Recommendation Report for Approval of Reserved Matters Following Outline Approval

REF NO:	BN/18/21/RES
LOCATION:	GTR land east of Fontwell Avenue Arundel Road Arundel BN18 0SB
PROPOSAL:	5000 sq m of light industrial floor space (ClassB1 (b)/(c) following grant of outline planning permission WA/22/15/OUT (resubmission following BN/57/19/RES). This site is in CIL Zone 1 (Zero Rated) as other development.

DATE 23-12-20	DRAWING No. WM/688/P11
------------------	---------------------------

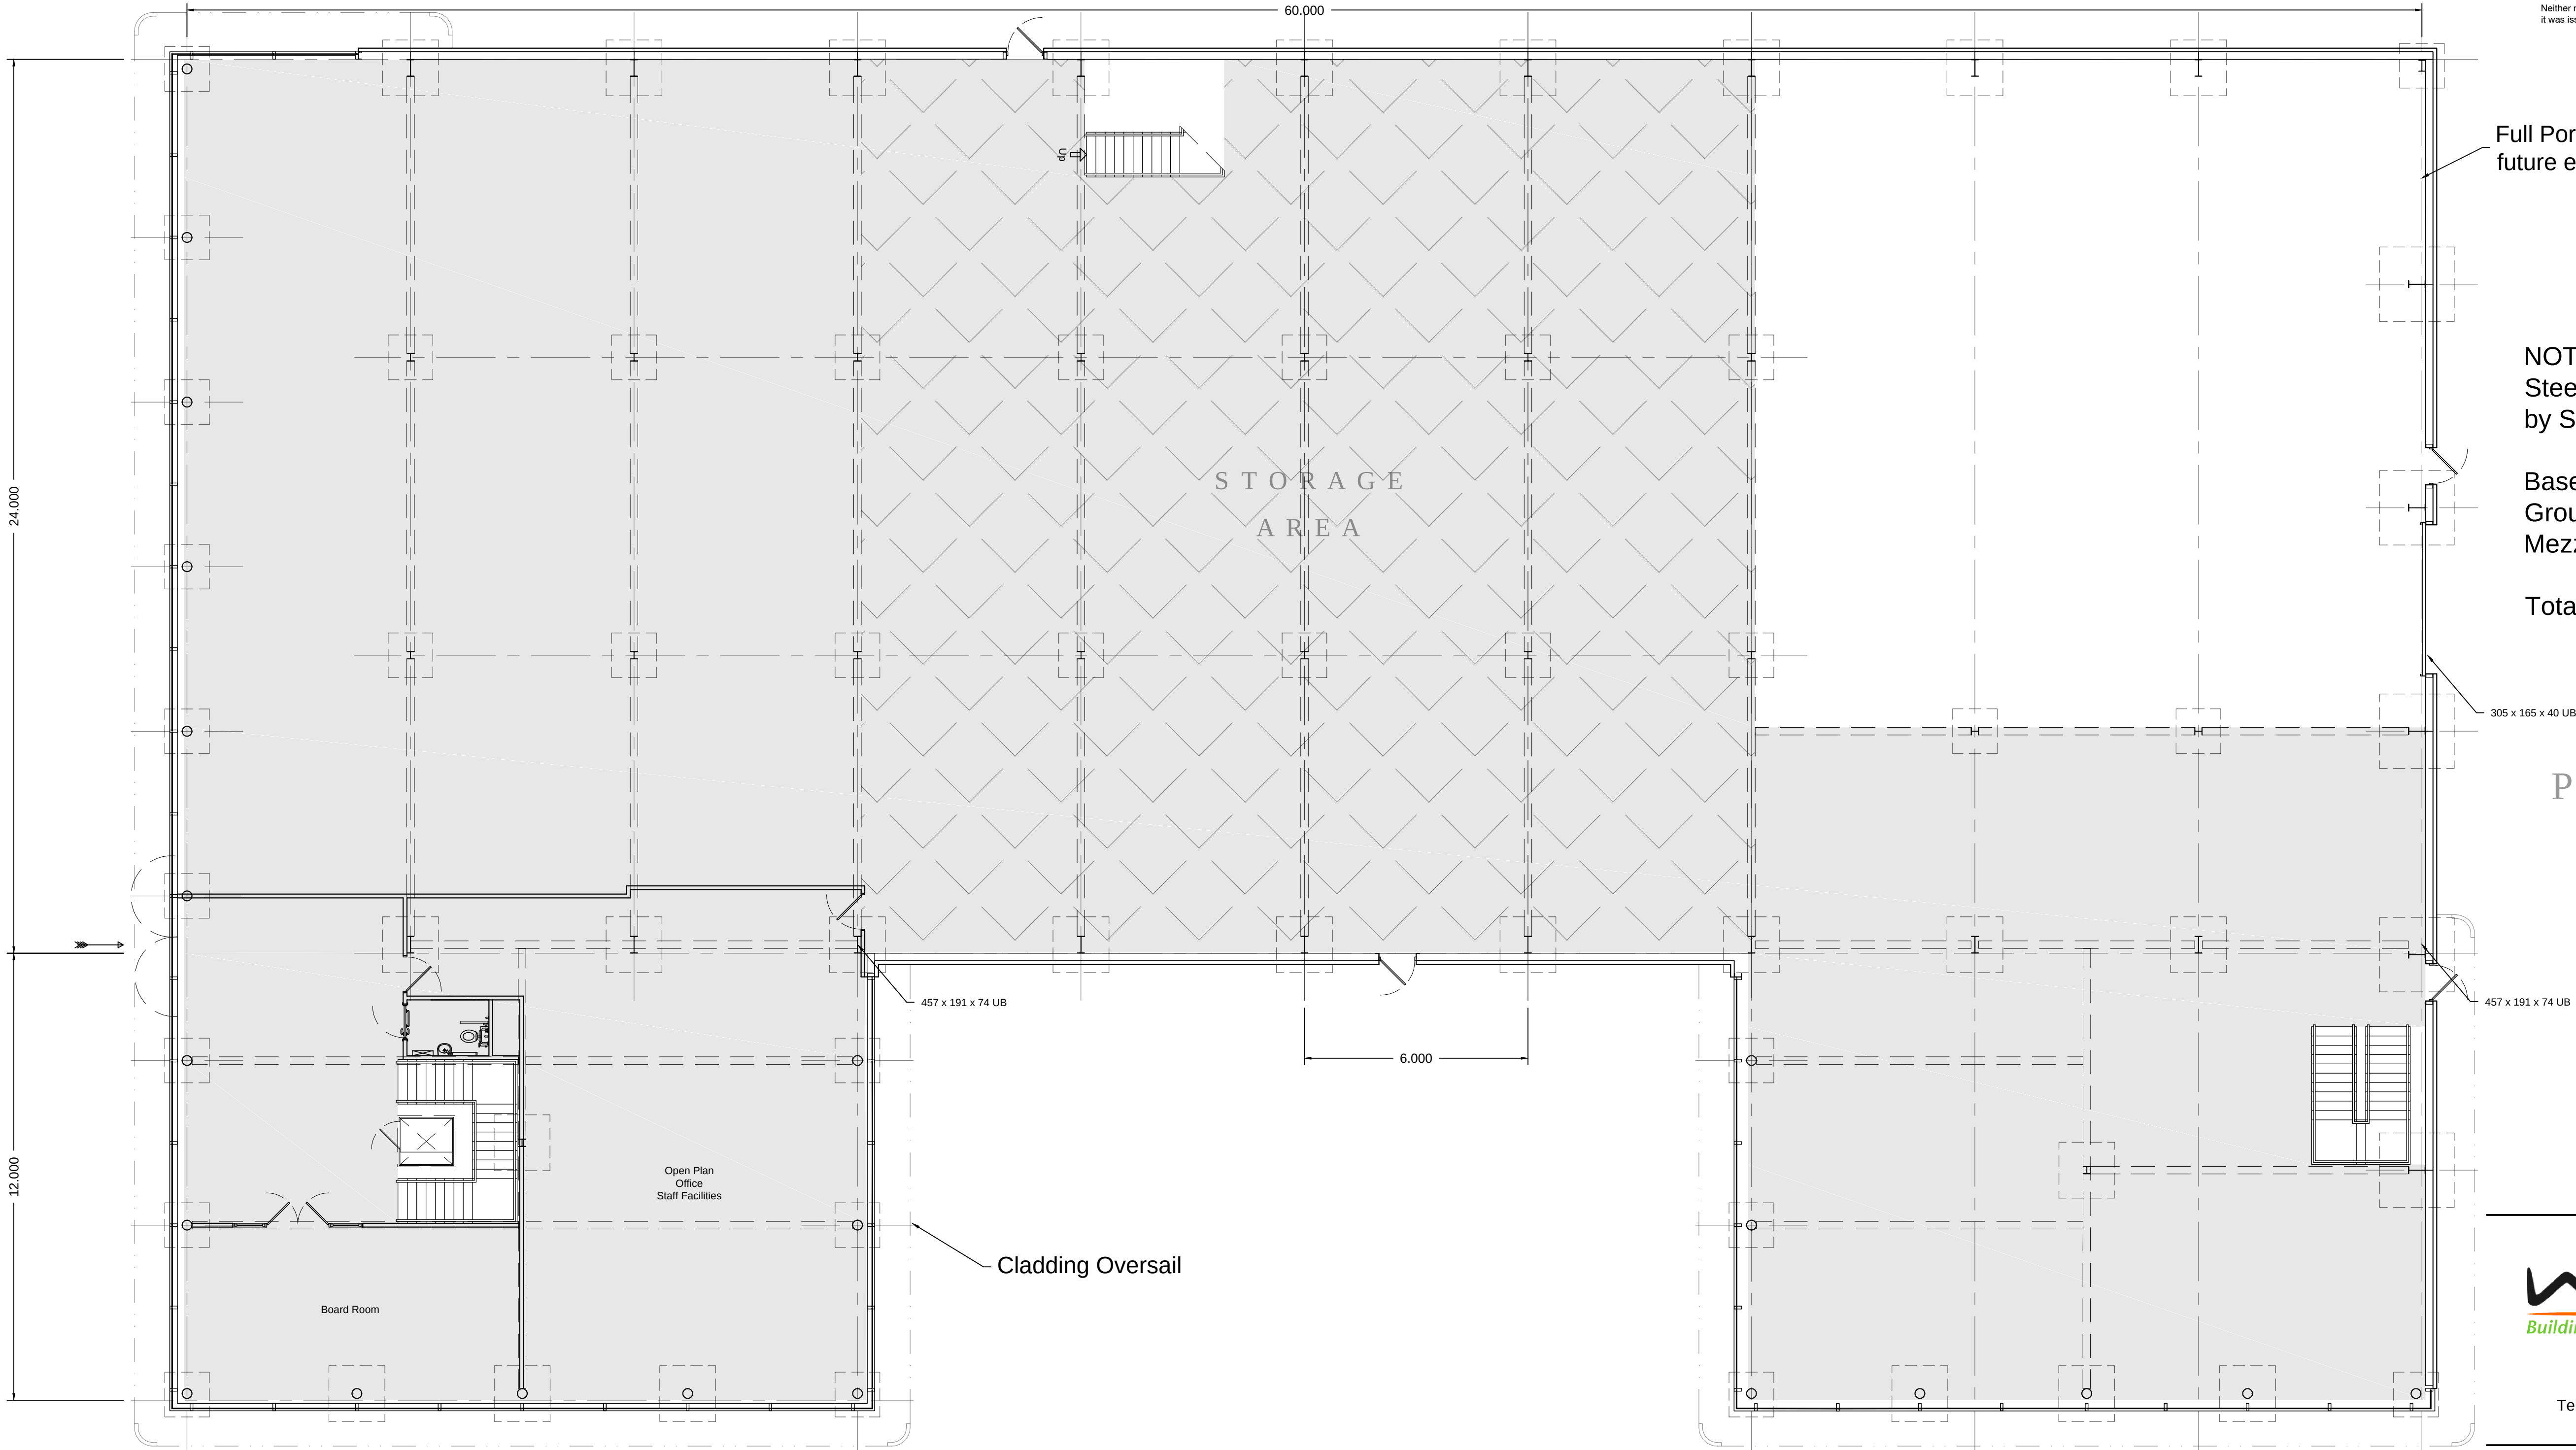
The design and access statement refer to, alternately, an eaves height of 8.5m (para 3) and 7.5m (para 3.6). The height shown on plan (WM/688/P11 - there does not appear to be a plan for Block B) identifies a roof height of 9.45m with a 4 roof pitch. The distinction between the eaves height which is not identified on the plans and the total height of the roof is negligible.

There is therefore a lack of clarity over the heights to be considered and conflict between the documents. In the opinion of the Parish Council the building, immediately adjacent to the existing and future residential properties, despite the gentle fall of the land is too high and not in keeping with the local area.

Fontwell
Appendix 1 - tree protection plan (3)

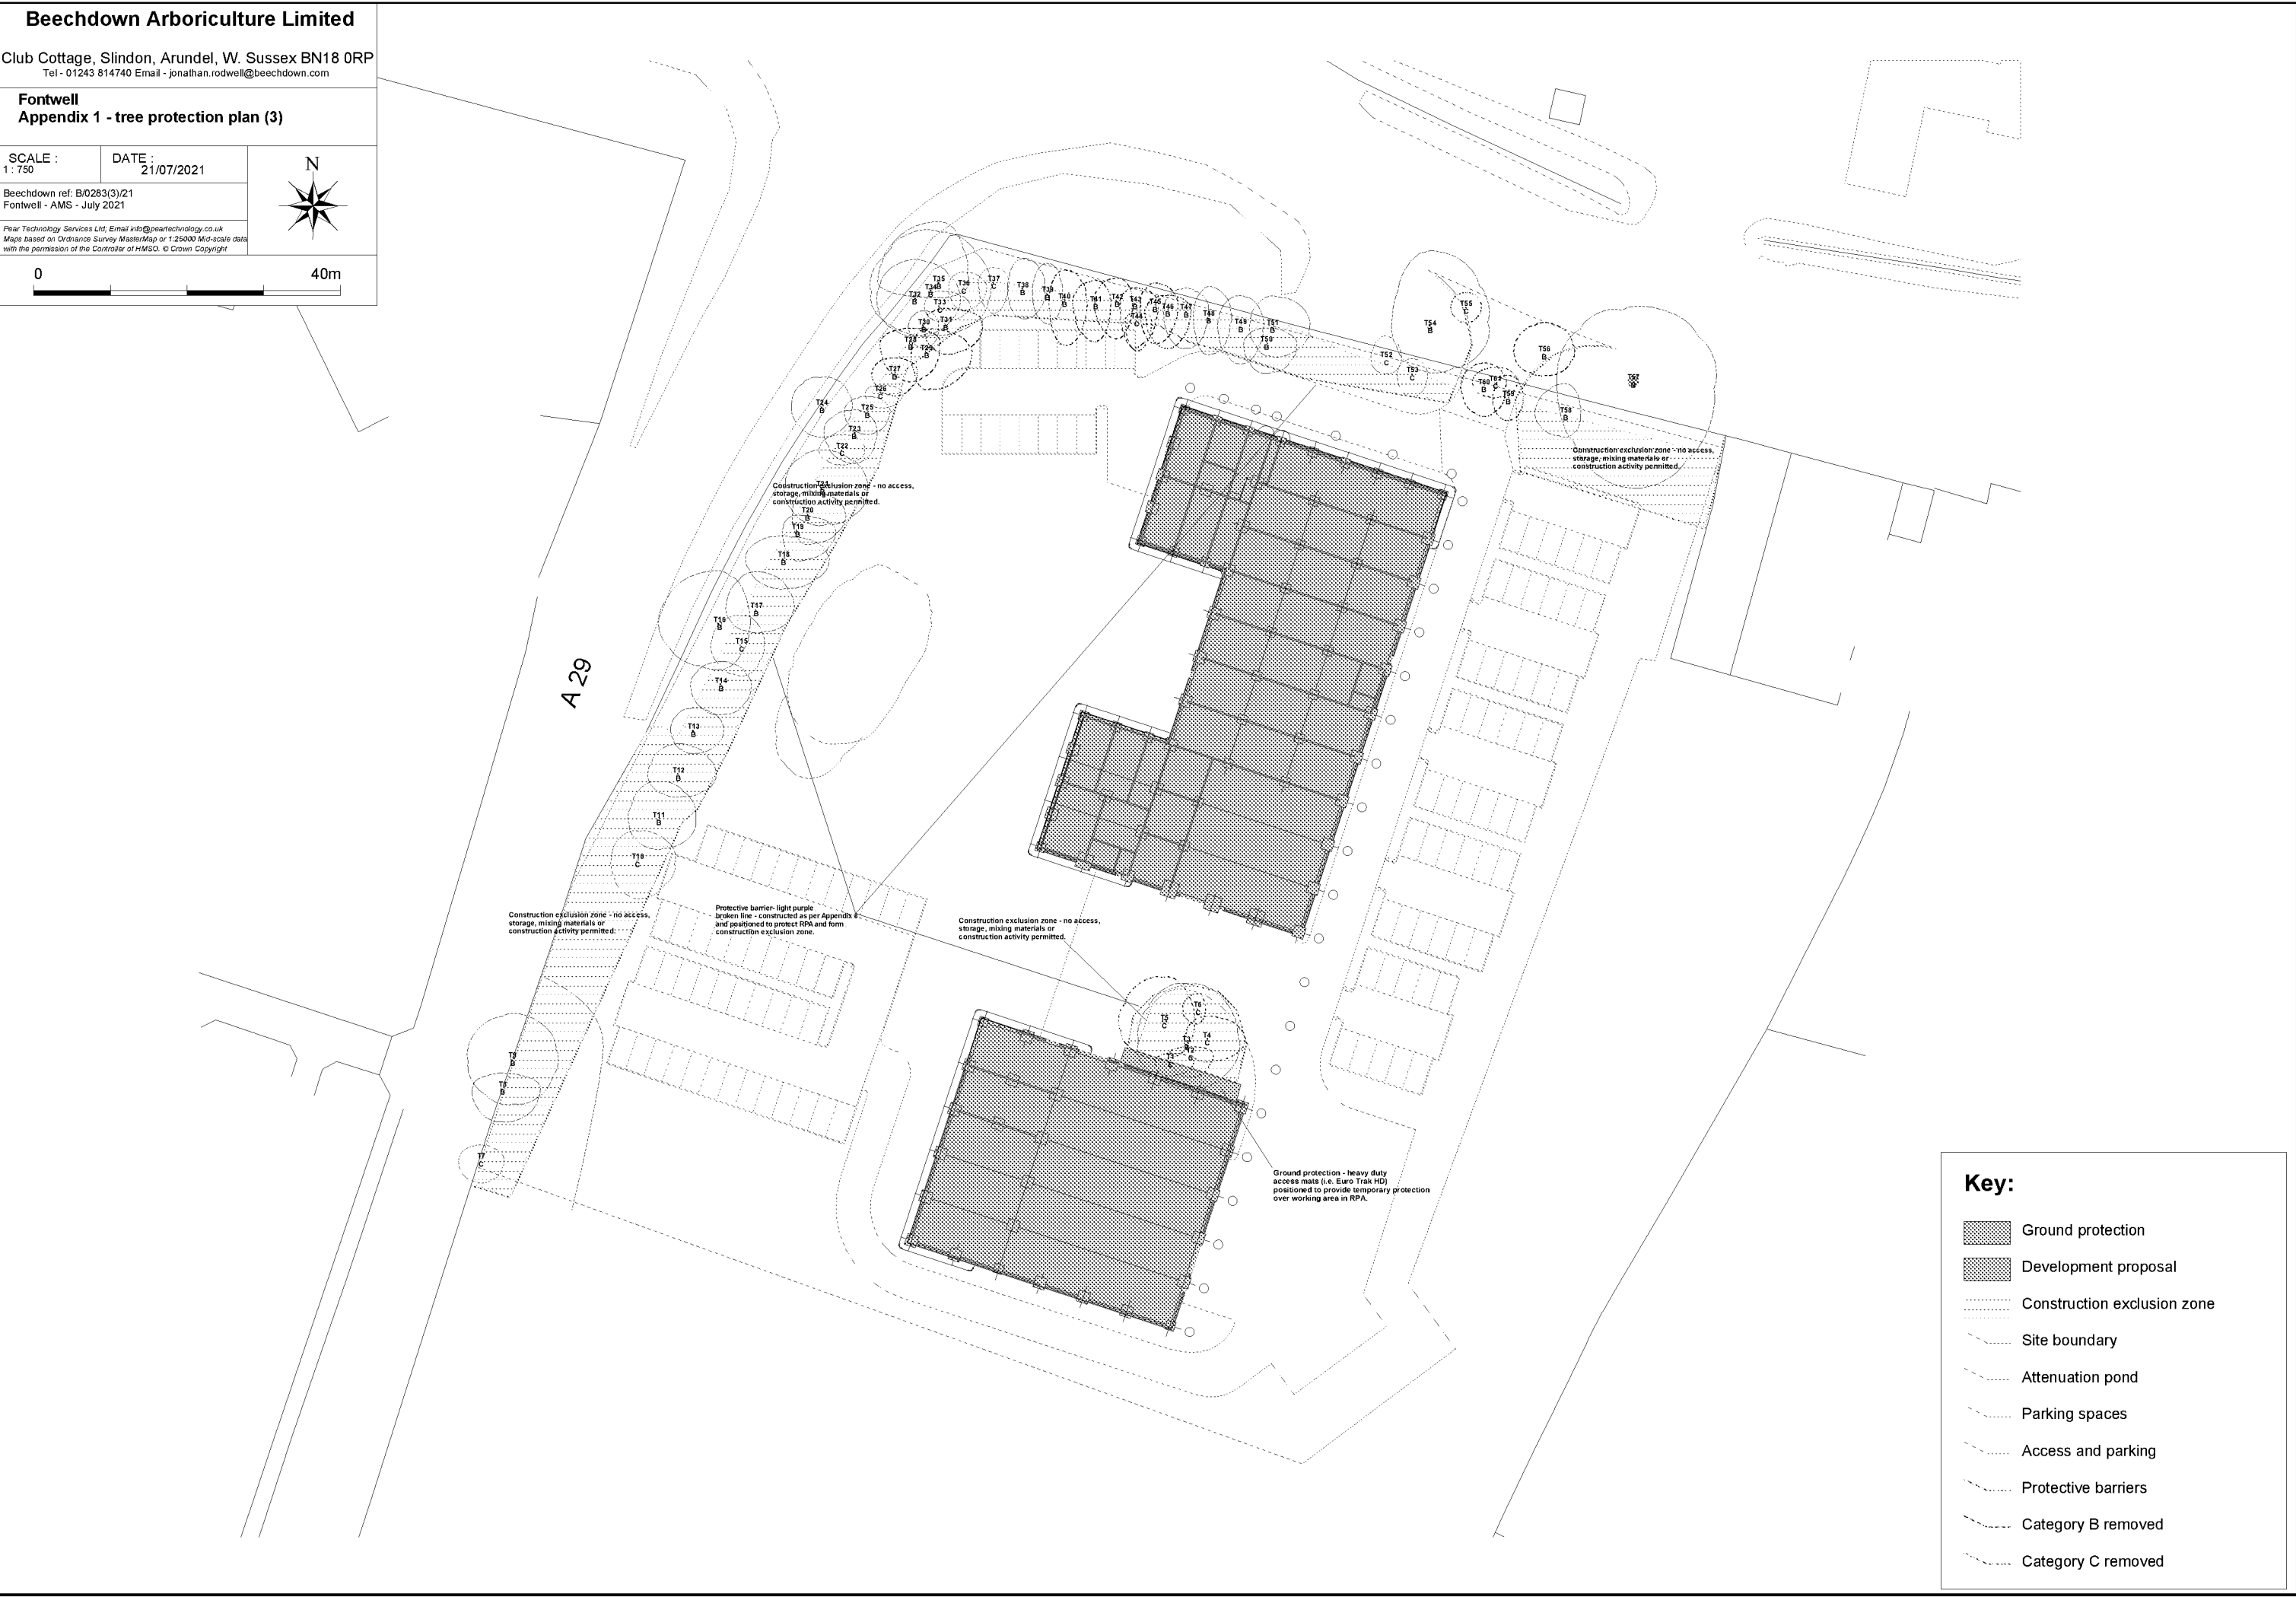
Through the determination of the previous reserved matters application (BN/57/19/RES) it was identified that there would be an encroachment of Building B into the root protection area (RPA) of an English Oak. However, it was identified that the buildings size was dictated by its use and as such could not be reduced whilst it could not be located further to the south due to the need to provide vehicular access. As a result of this encroachment it was identified as unlikely that the tree would reach full maturity but it was concluded that with a cyclical regime of minor pruning the tree could be retained as one that is prominent and of character. It was also identified that oak trees could be planted within the site to the east of the attenuation basin and that these trees would reach maturity without pruning.

The incursion within the RPA of the English Oak remains with this revised proposal and is identified through the Arboricultural Method Statement (AMS) with measures identified to minimise impacts of construction upon the tree. The Landscaping proposals also incorporate the three no. Oak Trees as was previously approved.
